**PREFERRED PROJECT REPORT  
MP 10\_0107**

**61 MOBBS LANE, EPPING – STAGE 1 TOWNHOUSE  
DEVELOPMENT**

**NOVEMBER 2010**

Project:
 EPPING PARK,
 BUILDINGS 1 & 2
 61 MOBBES LANE, EPPING
 Title:
 BUILDING 1 (TYPE 3
 TOWNHOUSE)

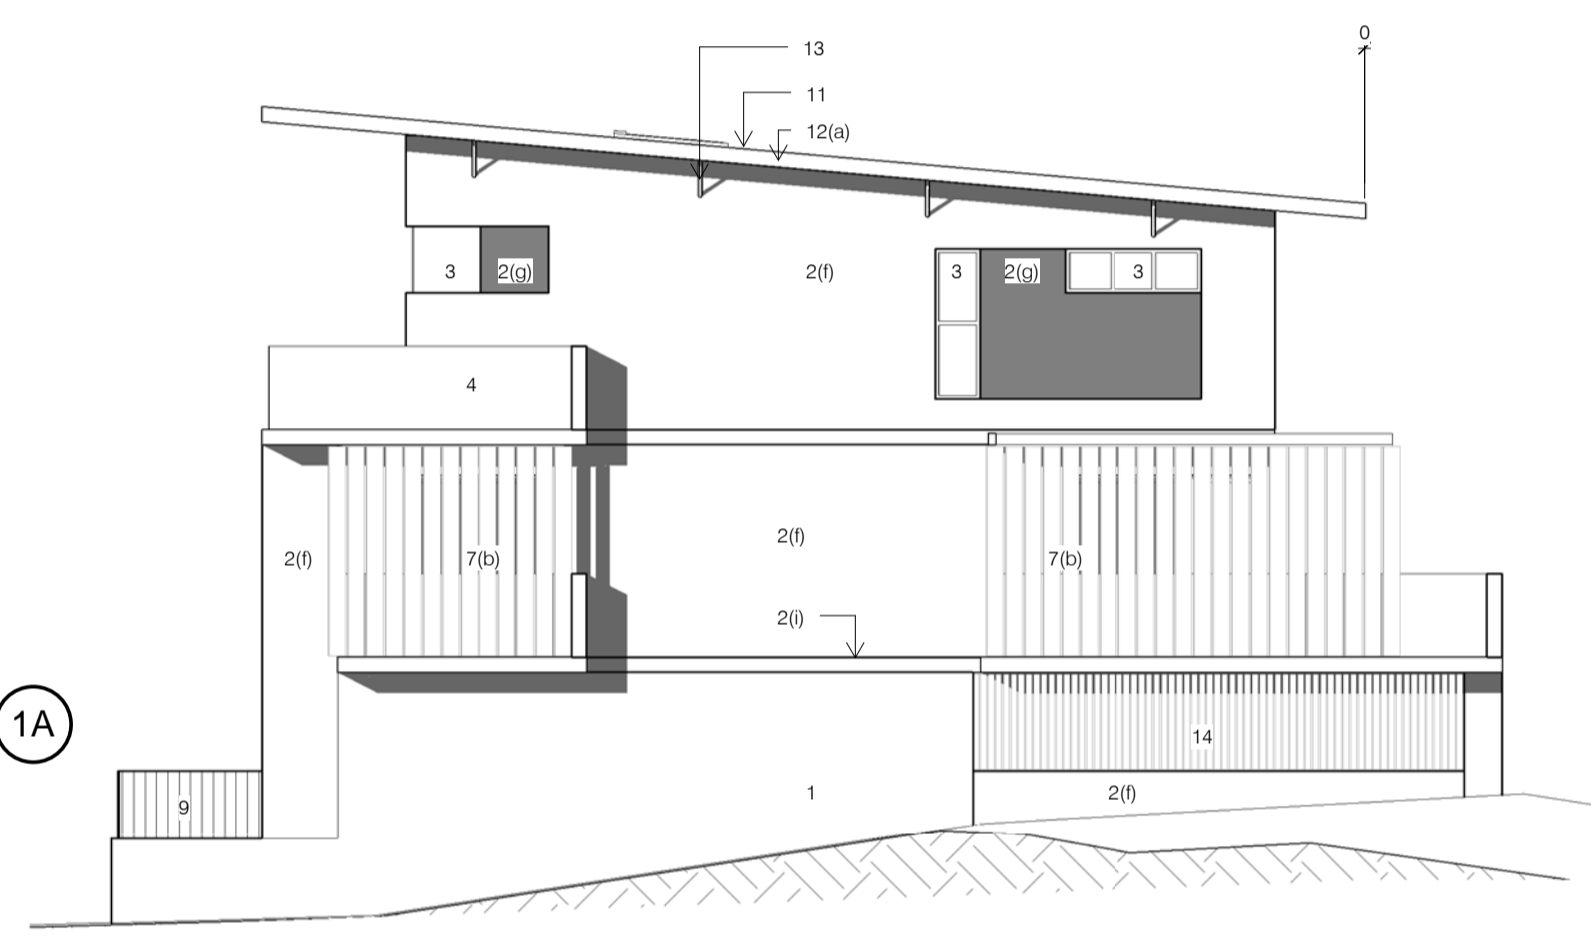
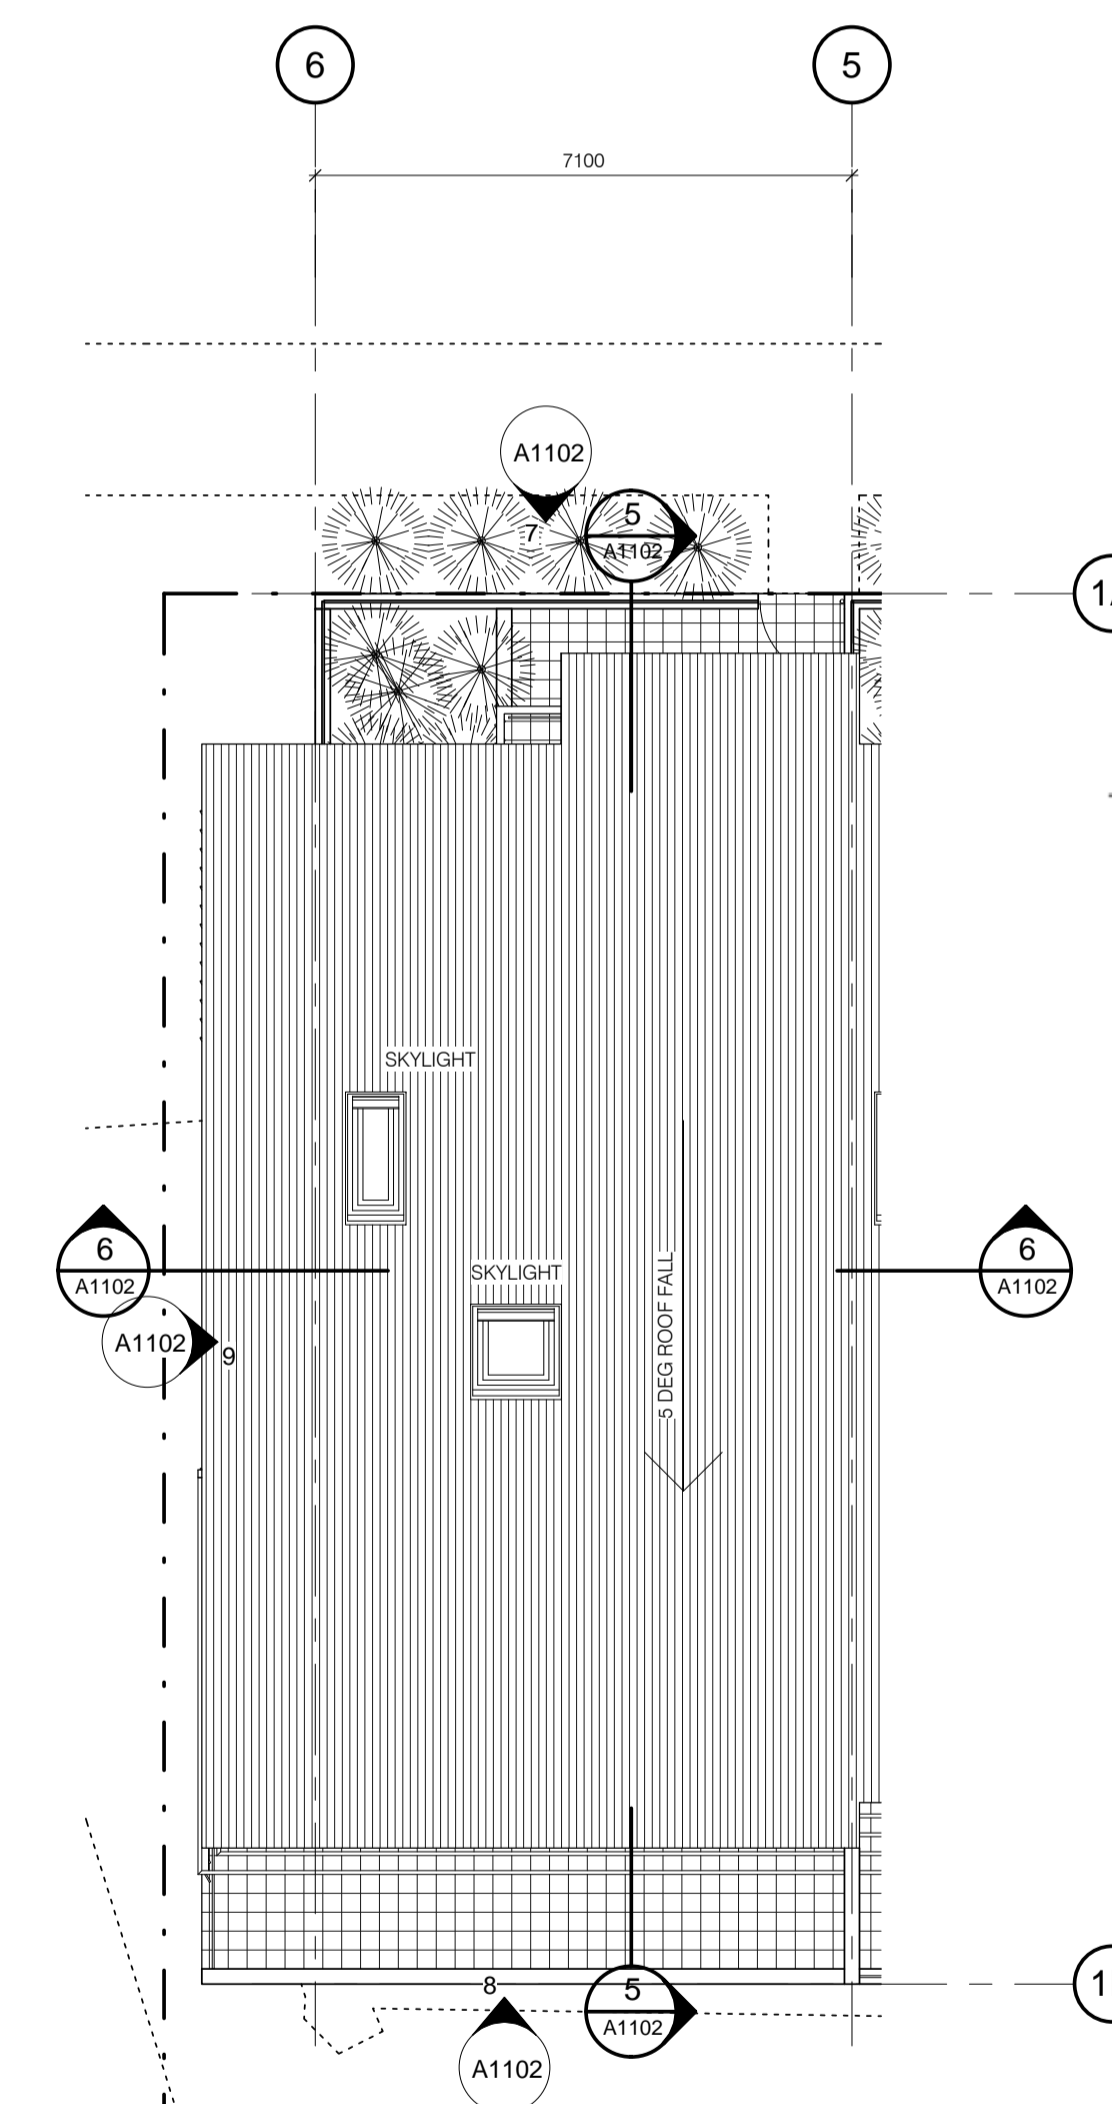
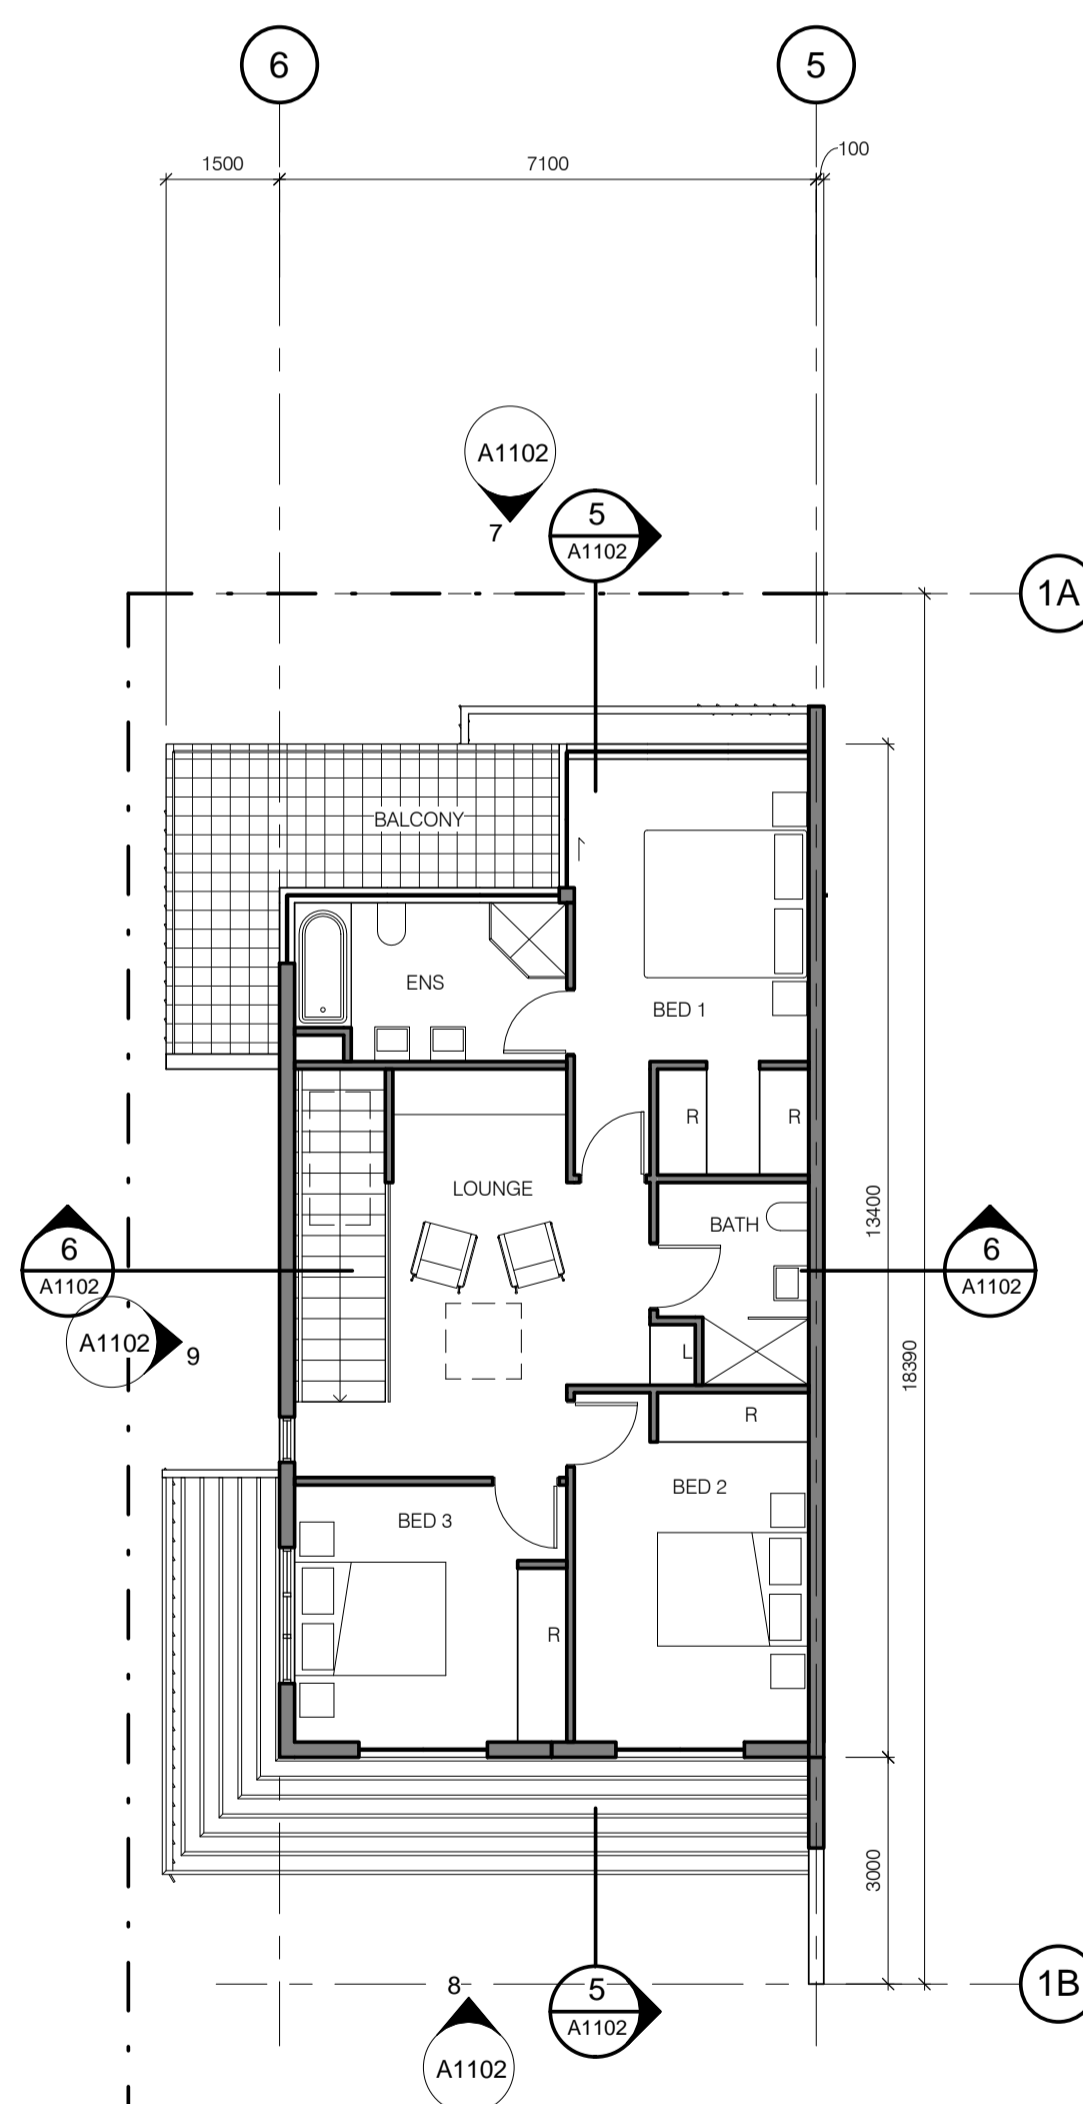
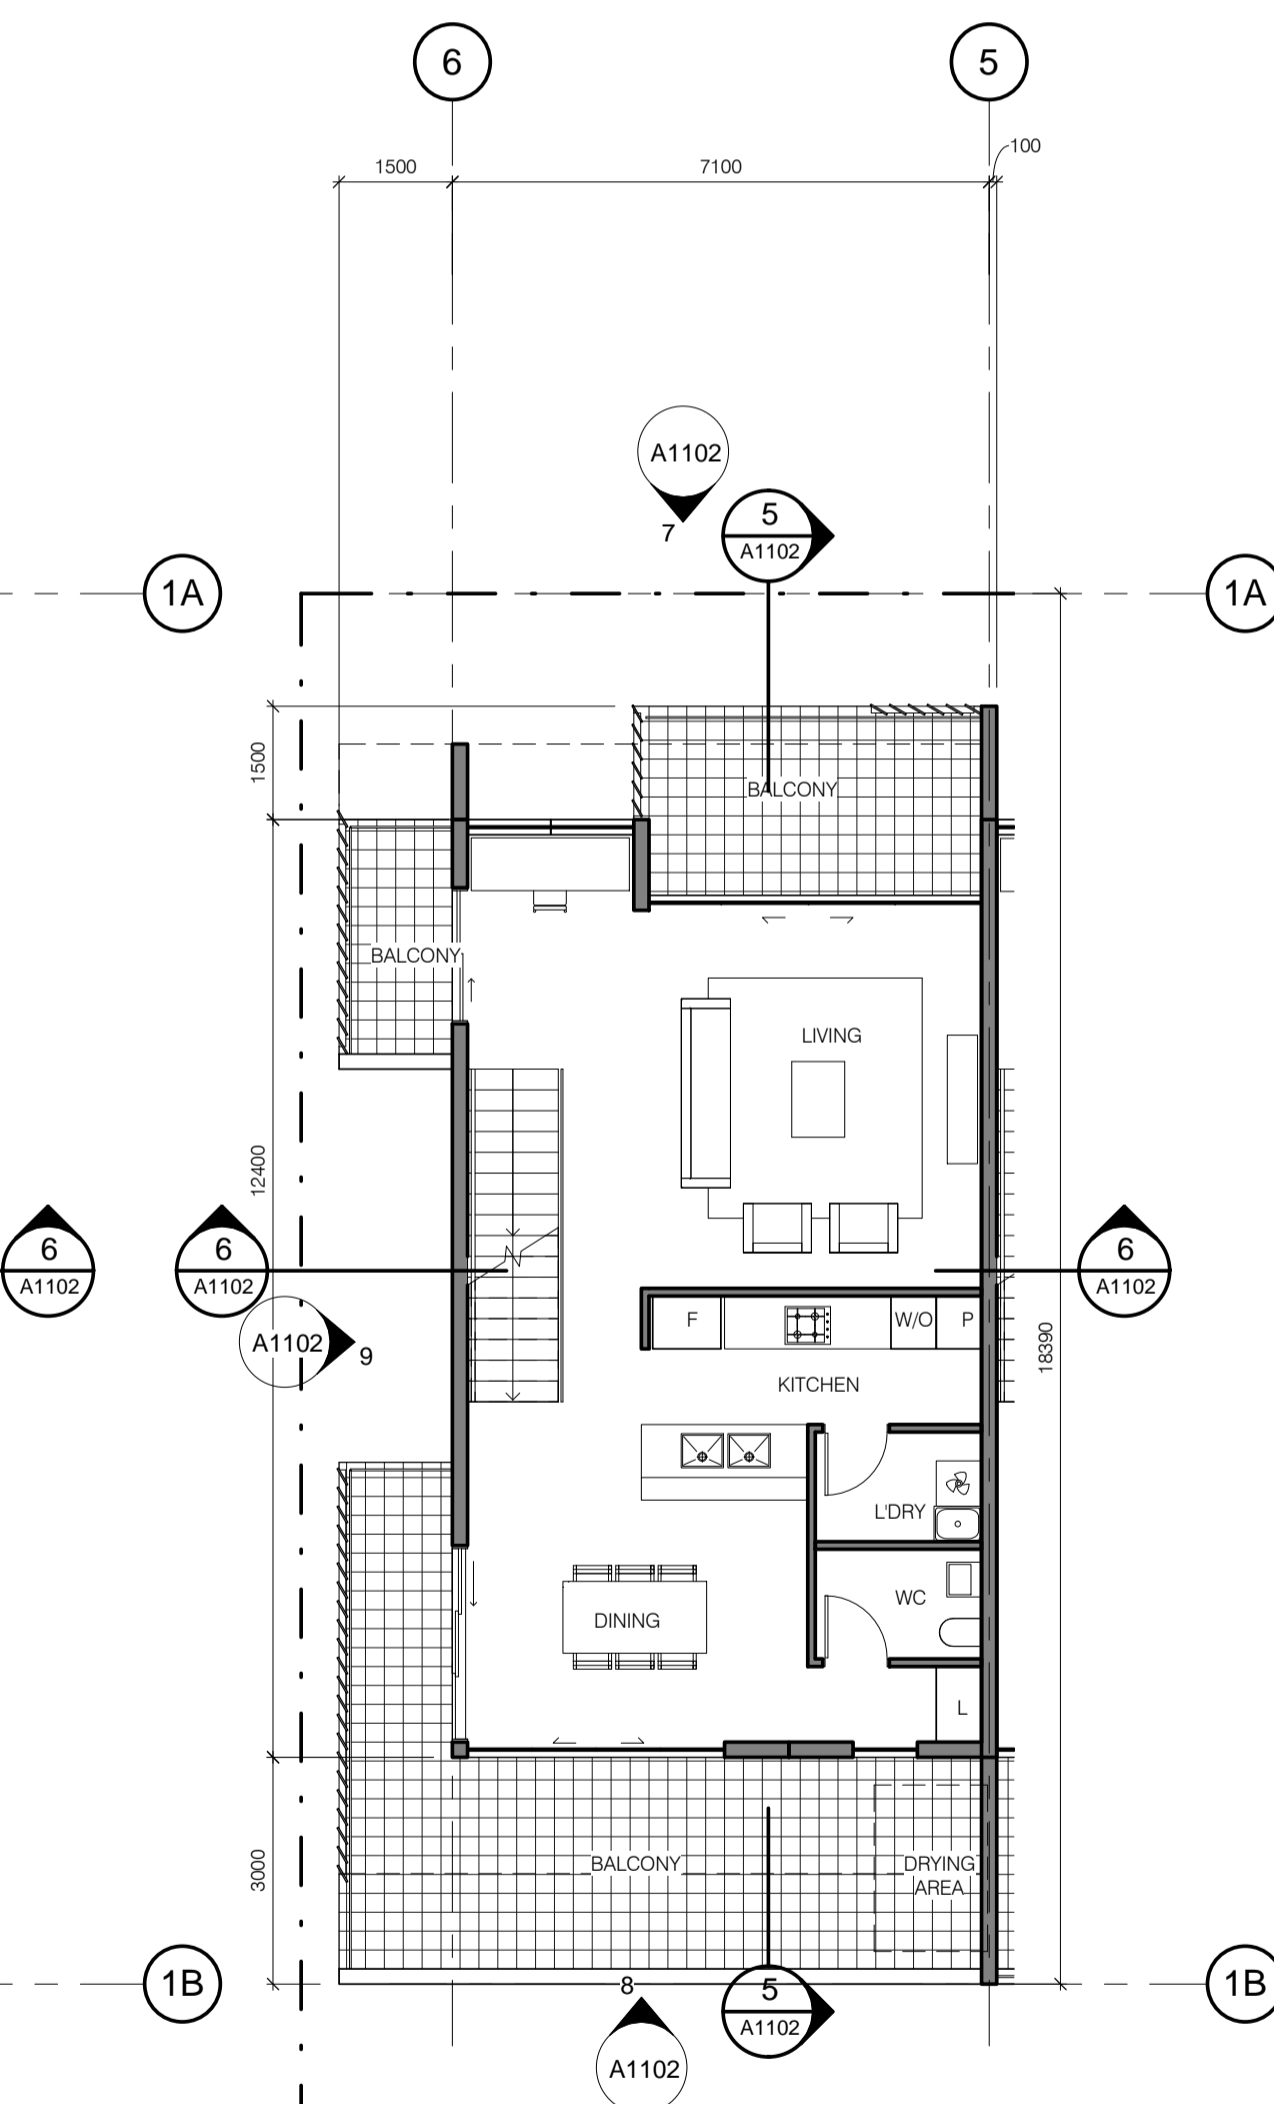
Issue: Increase passive surveillance from Buildings 1 & 2 towards Mobbs Lane.

Response: Buildings 1 and 2 have excellent surveillance towards Mobbs Lane as the buildings have a large balcony which directly over looks the street. In addition, the dining room and kitchen areas are orientated onto the balcony. These are rooms within a dwelling which are in constant use, thus providing constant surveillance. Refer to photomontage No. A1301 (attached in **Annexure 4**) which clearly demonstrates the relationship between the buildings and the street, and the position of the balcony.
